DELEGATED ITEM FILE REPORT - APPROVAL

Application No:	3/2012/0639/P
Development Proposed:	Conversion of barn into two dwellings, creation of curtilages and installation of new package treatment plant at Windy Hills Farm, Chipping, PR3 2QR

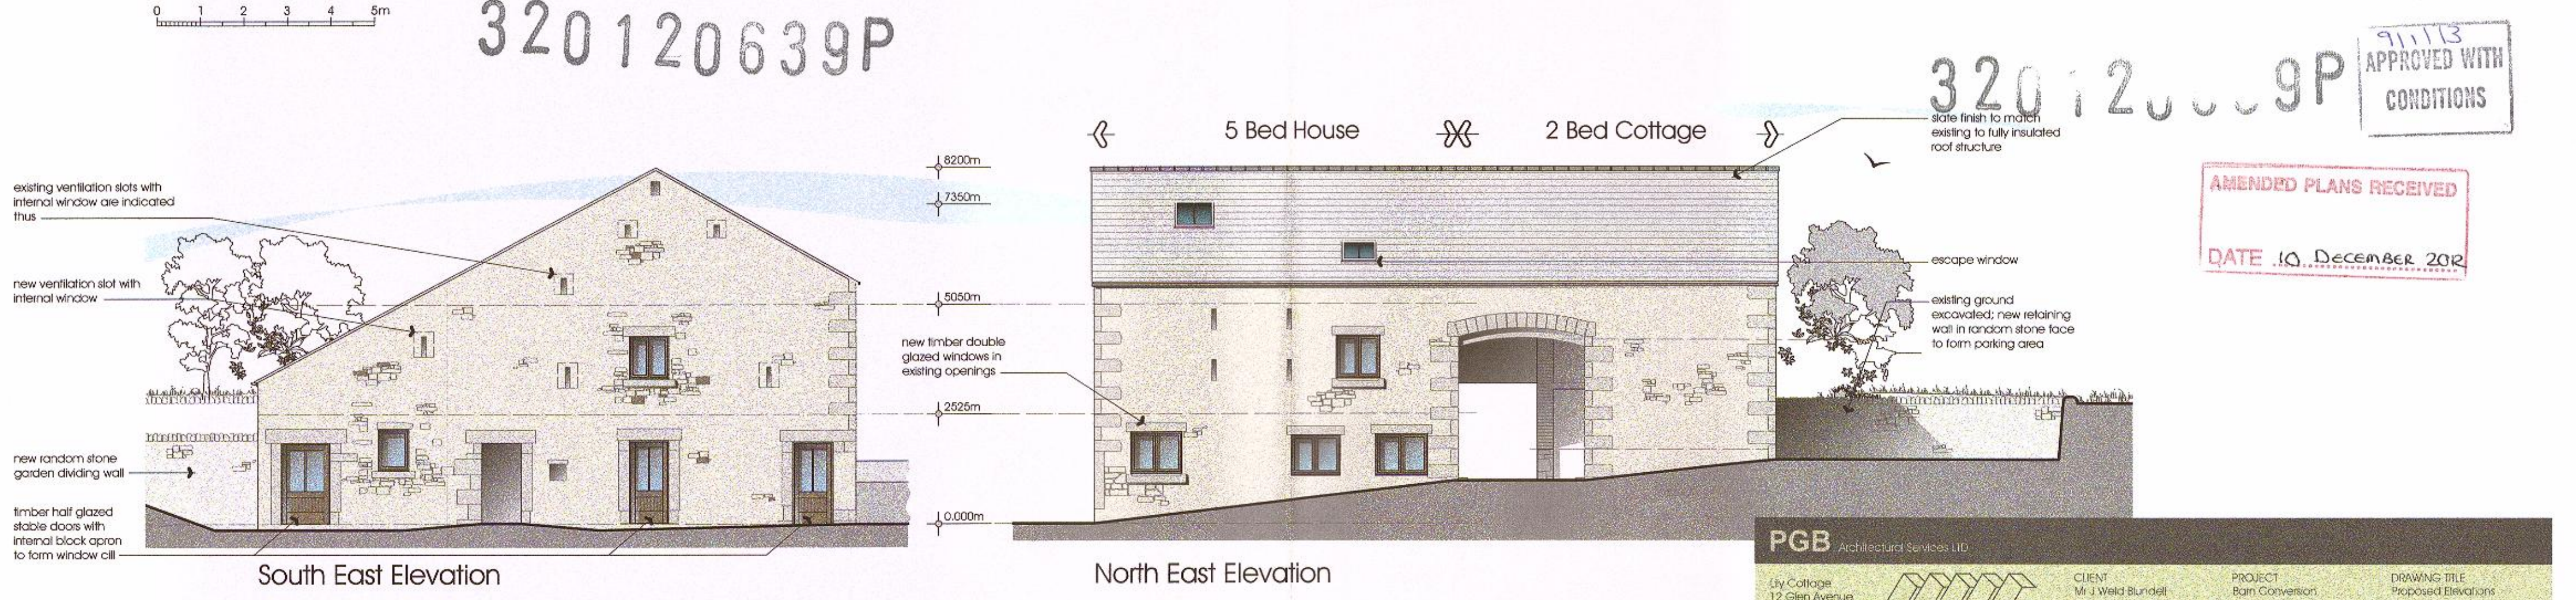
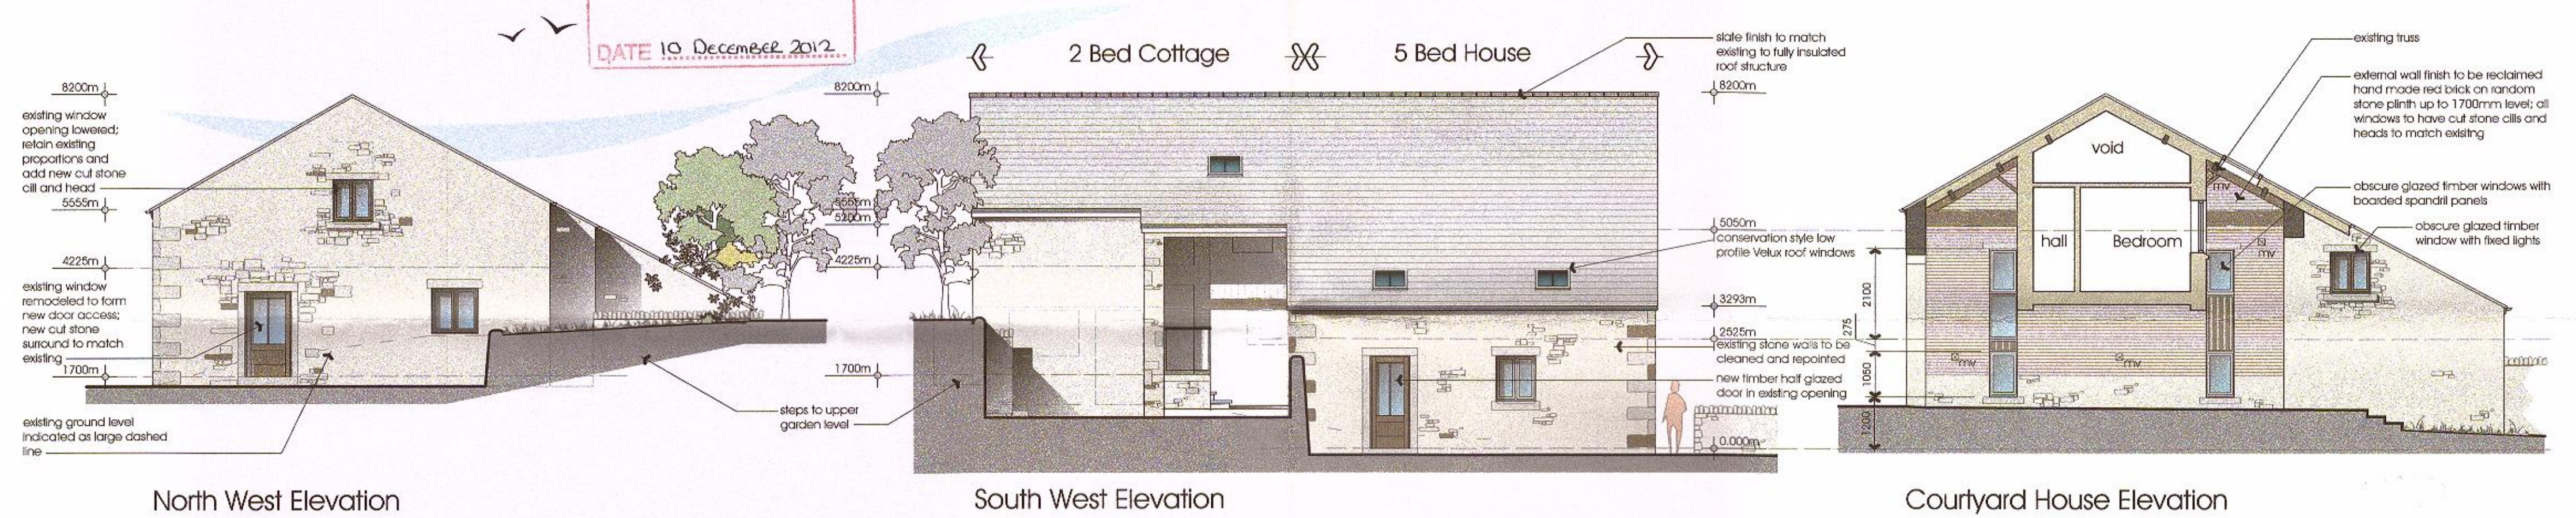
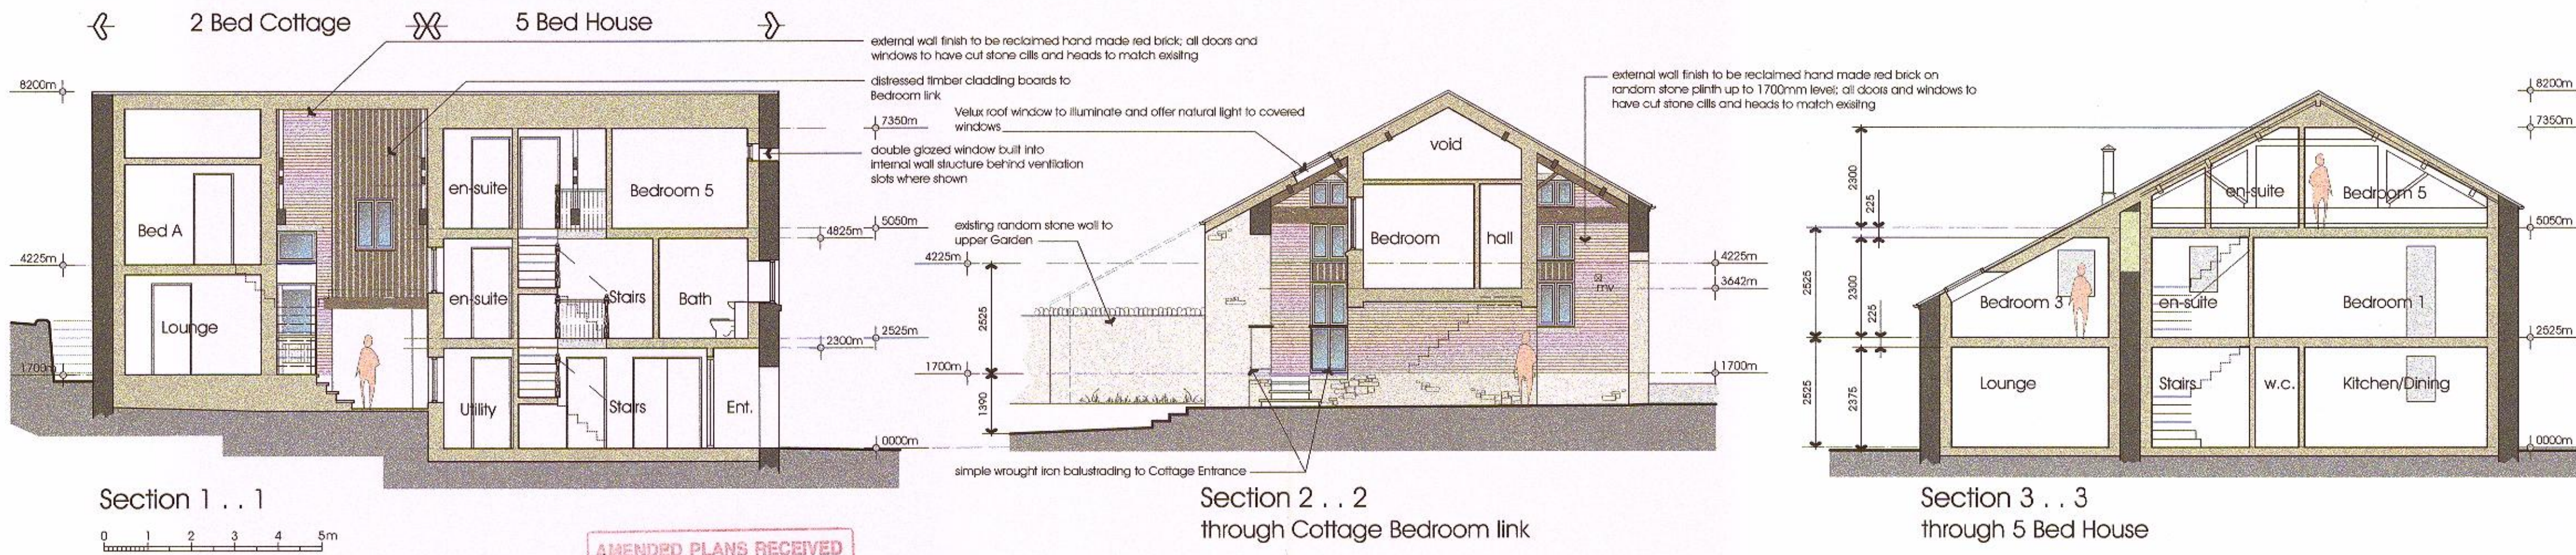
In design terms, the LPA had serious concerns over the domestication of the barn which would have resulted from the design initially proposed. The LPA has thus negotiated with the agent to reduce the number of roof lights proposed from 9 to 5, to remove the two stainless steel flues and revise the associated residential cartilages, which encroached severely into the adjacent field. Amended plans dated 10 December 2012 have thus been received, and it is considered that the distinctive character of the barn, a heritage asset, will be retained.
